Date: 17-Dec-2025
Our Ref: 2025/93213

**TOWN AND COUNTRY PLANNING ACT 1990
TOWN AND COUNTRY PLANNING (GENERAL PERMITTED DEVELOPMENT) (ENGLAND)
ORDER 2015 – SCHEDULE 2, PART 1, CLASS A.1 (g)
AT: 1, Lockgate Rise, Birkenshaw, BD11 2PL
Prior notification for single storey rear extension. The extension projects 4m b**

The Authority has considered your application, and it has been determined that the proposal is not acceptable and prior approval is hereby **Refused** for the following reason(s);

Drawing Title  
**PROPOSED**

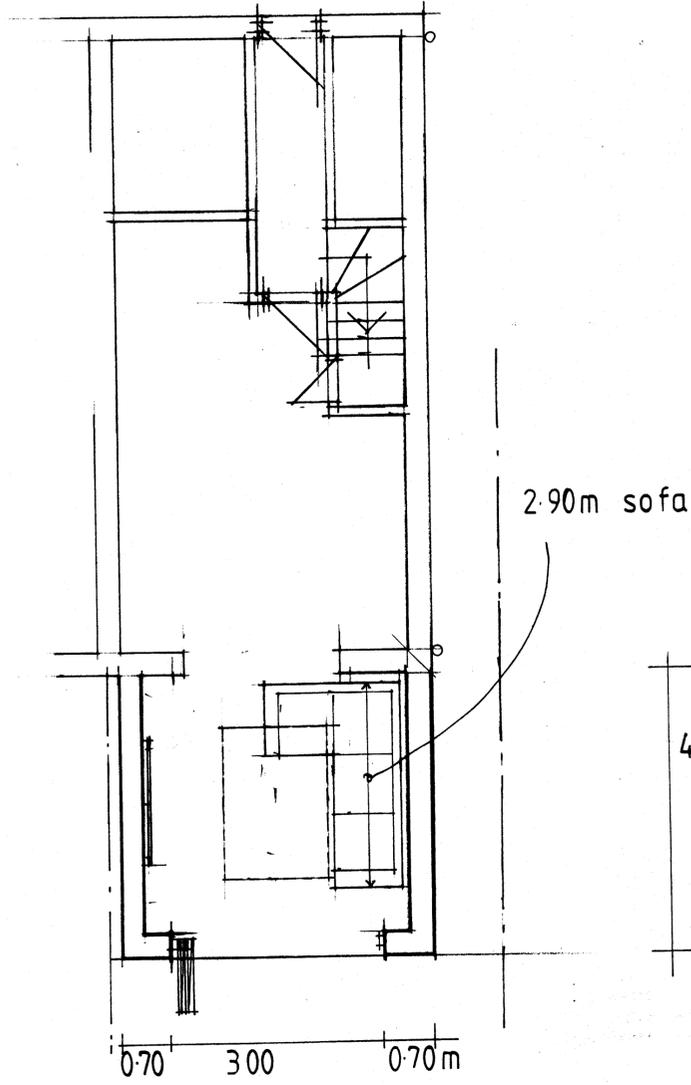
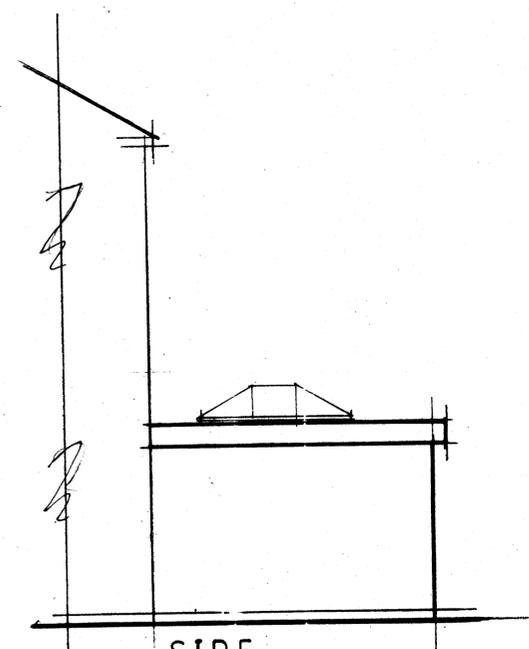
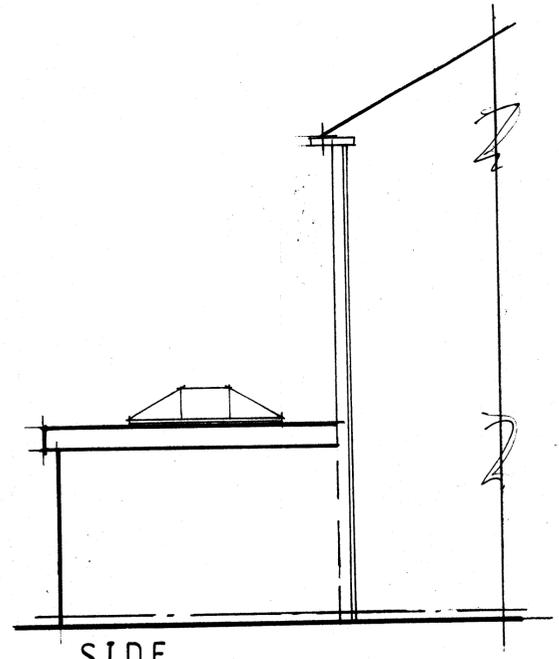
The proposed enlargement does not benefit from a general planning permission under Article 3(1) and Class A, Part 1 of Schedule 2 of the Town and Country Planning (General Permitted Development) (England) Order 2015 as the rear projection extends beyond a wall forming a side wall of the original dwellinghouse and has a width greater than half the width of the original dwellinghouse contrary to sub-paragraph A.1(j) of Class A.
